**Maxwell Underground Coal Mine Project (SSD 9526)
Request for Additional Information**

I refer to the above application and to the Submissions Report dated November 2019. Following further review and consultation with relevant agencies, the Department has identified several areas where additional information is required (see **Attachment A**).

Attachment A

Figure ES-1

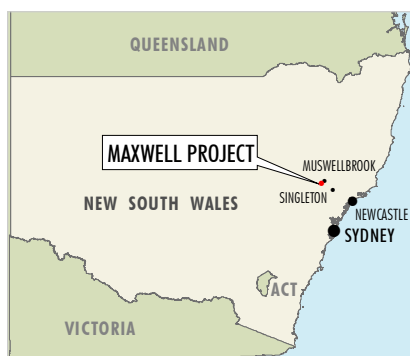
9. Please provide a high-resolution version of Figure 1-1 (Regional Location) from the EIS, preferably in JPEG format. Please include the locations of the Coolmore and Godolphin horse studs and Hollydene Estate on this figure.
10. In Figure 3-1, there appear to be some geological structures (delineated with straight blue and brown lines) which are not identified in the legend. The Department requests clarification in this regard.
